Subject: Proposed Single Storey Extension - 21 Lennox Street, Bognor Regis - BR/294/1/17/PL

Re: Proposed single storey extension at 21 Lennox Street, Bognor Regis

PROPOSED SINGLE STOREY EXTENSION AT 21, LENNOX STREET, BOGNOR REGIS
FOR MR. C. PATEL.

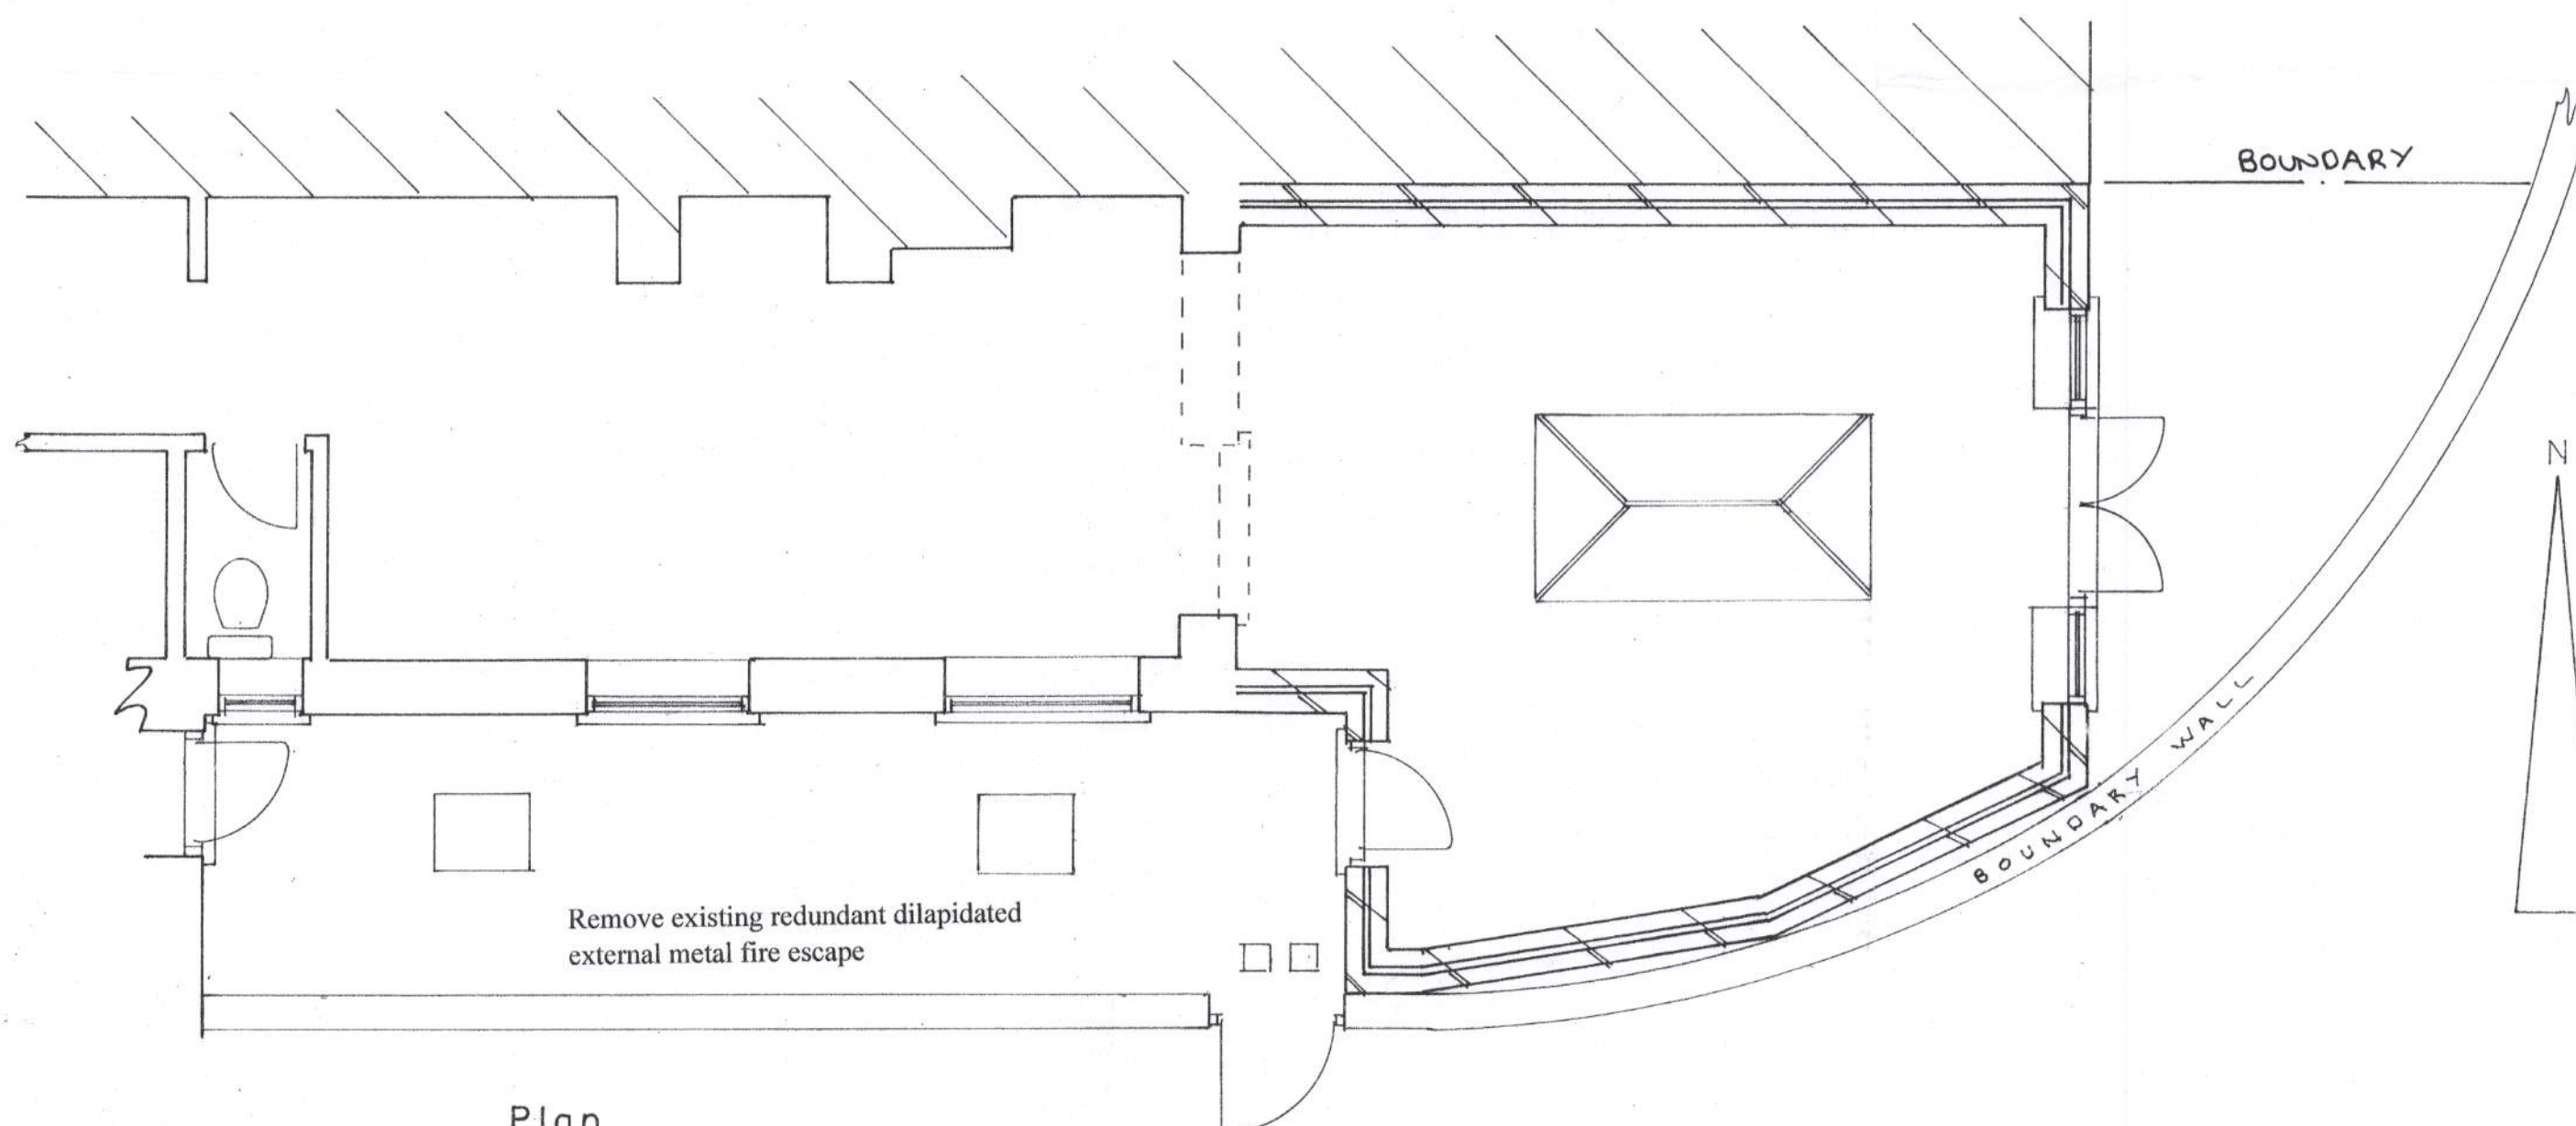
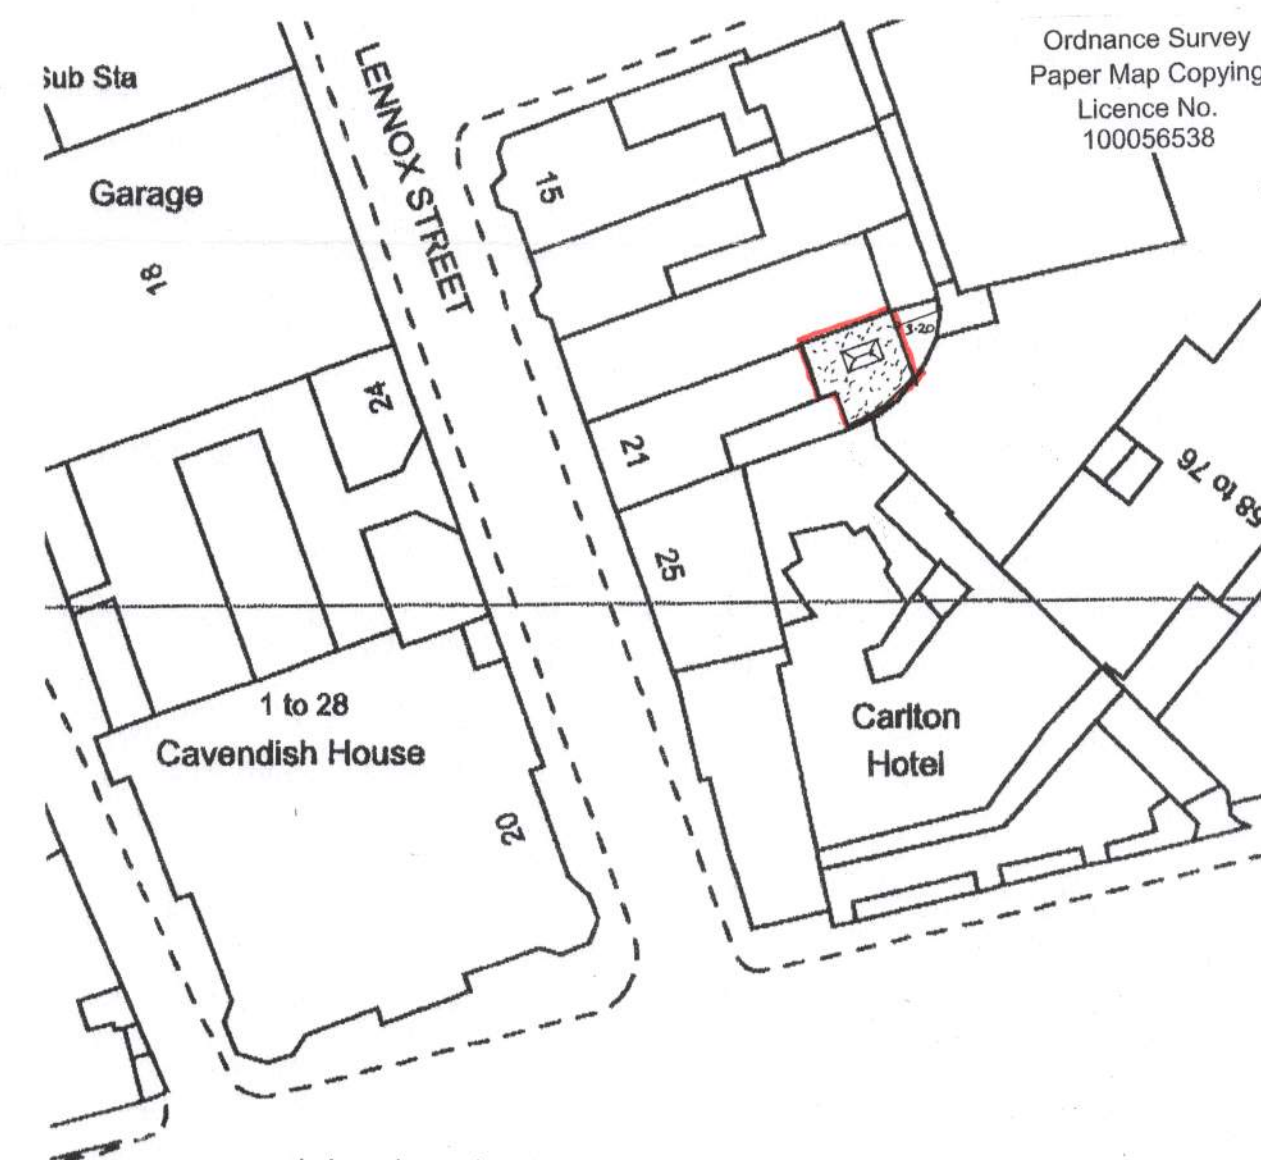
2. Looking at the plans deposited with your planning application, it would appear that it has been designed with a main access to the extension in a position which would require permanent access to the property over our client's land, which is, of course, beyond the scope of the right of way. Please confirm.

3. On the plans it appears that the wall to the east side of the Carlton car park at the point where the gate of 21 Lennox Street opens onto the car park is shown in an incorrect position, approximately 2 metres to the east. Please confirm that this will be rectified.
